Application no: **3/2021/1022**

Address: **Loft Shay Farm Clitheroe Road Ribchester PR3 2YQ**

Proposal: **Proposed single storey extension, garage and modifications to existing dwelling as approved under planning reference 3/2021/0670.**

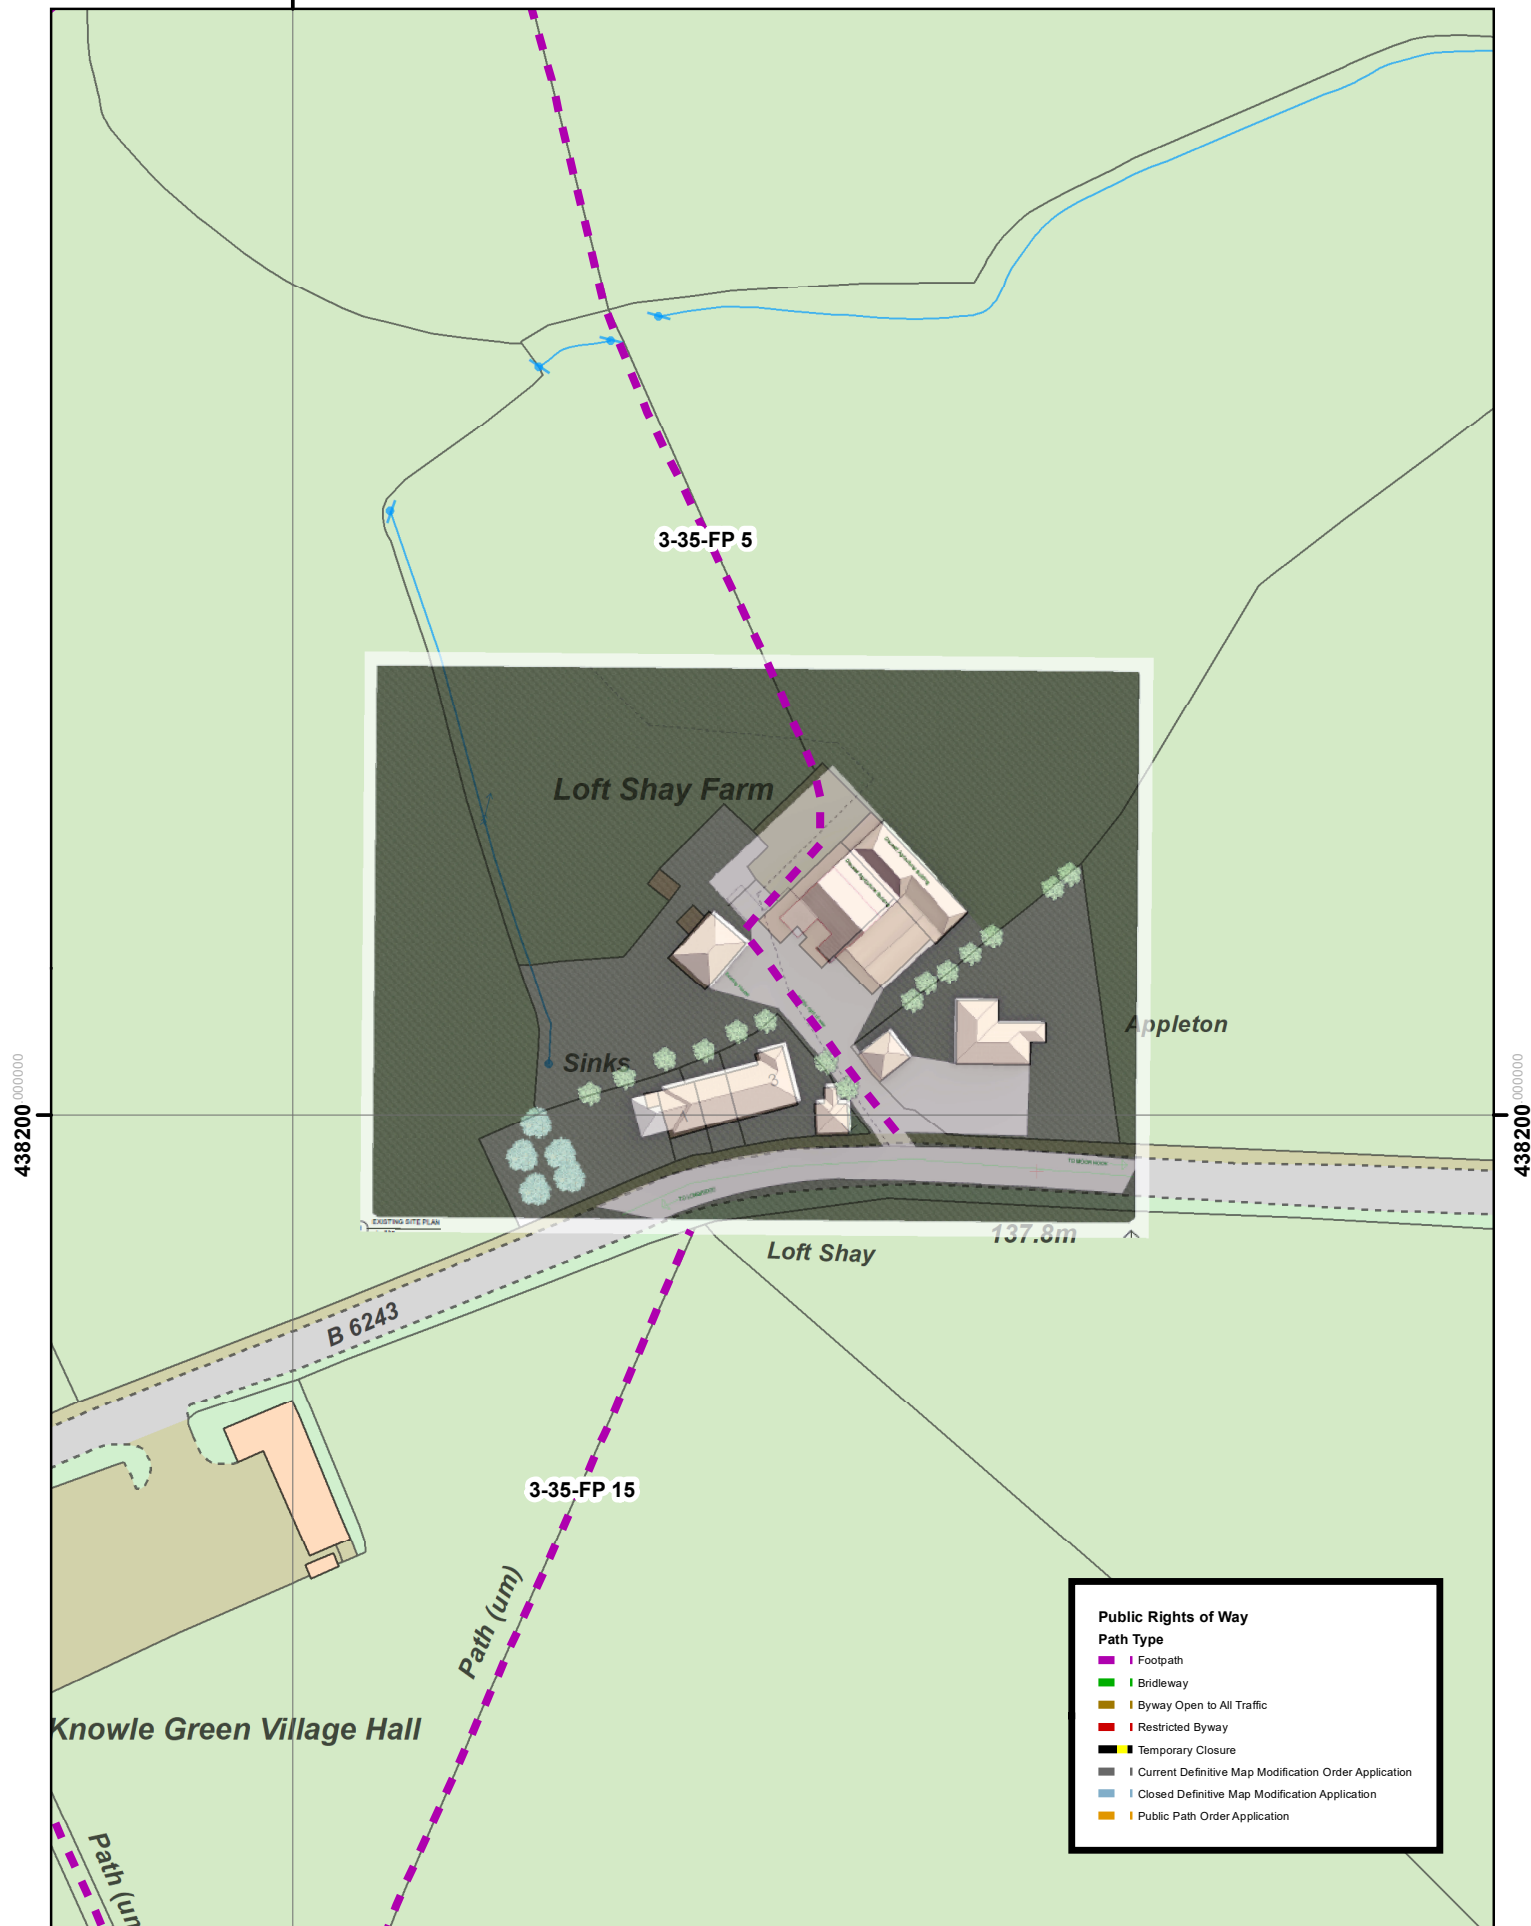
The LHA previously responded to the application on 1st November 2021 requesting further information regarding the diversion of Public Footpath 3-35-FP5. The Agent has now submitted a revised plan of the diversion which will be reviewed below.

The LHA have reviewed the submitted documents and have no objection to the proposal and the diversion of Public Footpath 3-35-FP5 subject to an application is submitted to the Local Planning Authority under Section 257 of the Town & Country Planning Act regarding the diversion. This should be in consultation with the LHA.
